Our Ref: EP/86/26/NMA

**Section 96A of the Town & Country Planning Act 1990 (as amended)
Town and Country Planning (Development Management Procedure) (England) Order 2015
(as amended) - Article 10**

Non-material amendment following the grant of EP/14/26/HH relating to a change in first floor roof light position to serve en suite shower room, amended windows on the north and south elevation and amended window frame colour.

7 The Roystons East Preston BN16 2TR

PROPOSED ELEVATIONS

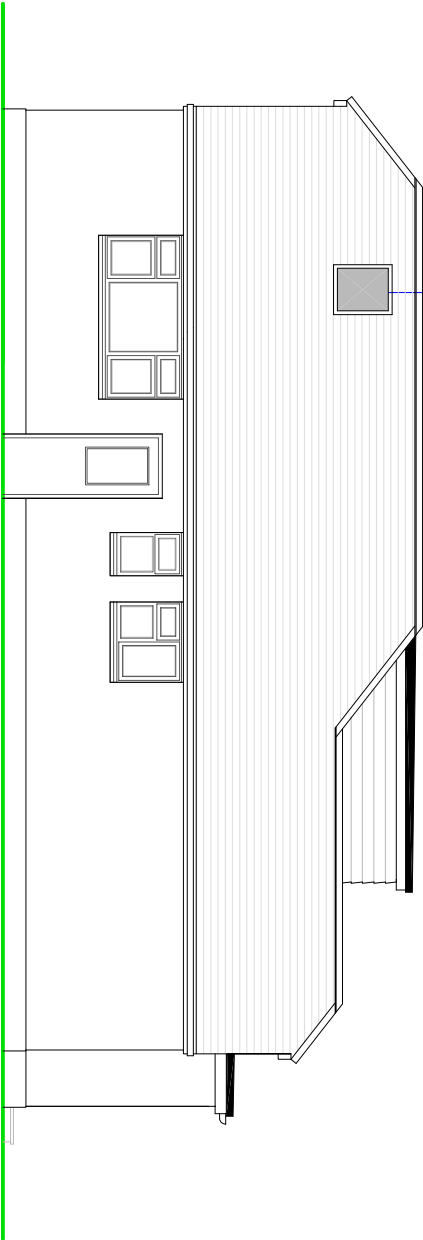
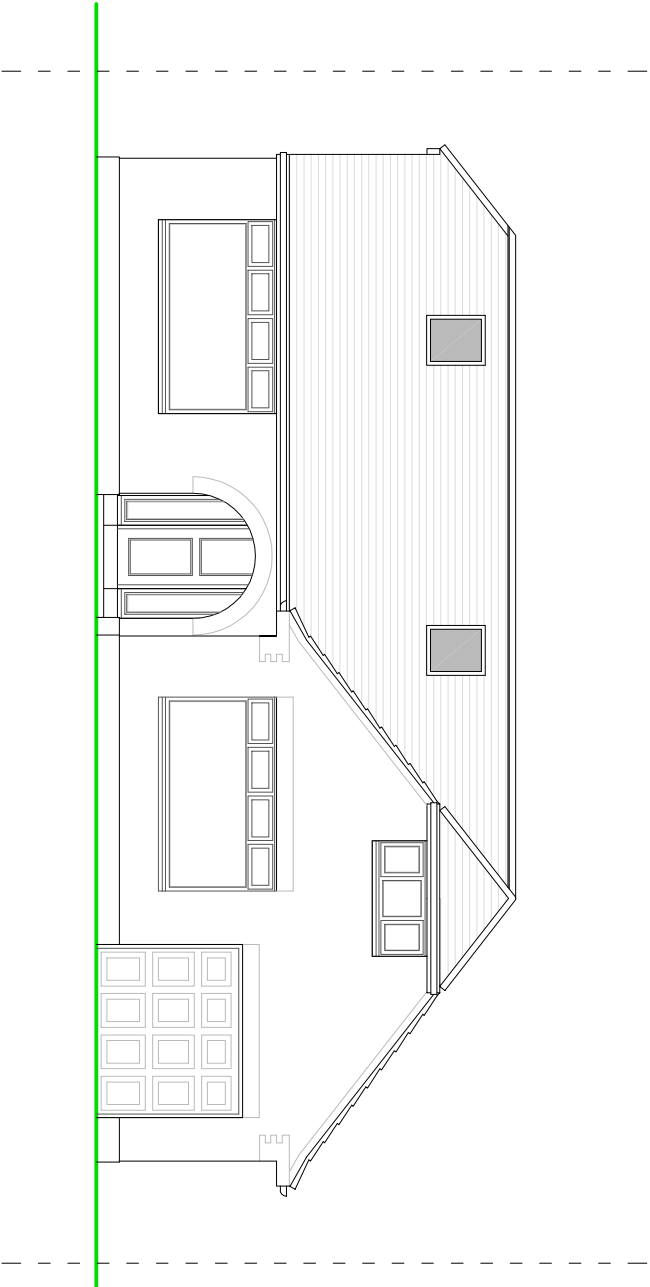
The proposal seeks the relocation of a rooflight from the southern facing roof slope to the northern facing roof slope. The roof light proposed on the northern roof slope would be obscurely glazed. The remaining roof light on the south elevation, as well as that proposed on the northern roof slope, would be slightly larger in size and sited marginally closer to the gable end. Additionally, the windows are proposed to be amended to a charcoal colour, rather than the previously approved white.

From the information submitted I am able to take the alterations as a minor amendment to EP/14/26/HH. The new Proposed First Floor Plan F, Proposed North and East Elevations B and Proposed South and West Elevations C are therefore accepted as part amending the previously approved Proposed First Floor Plan, Proposed North and East Elevations and Proposed South and West Elevations.
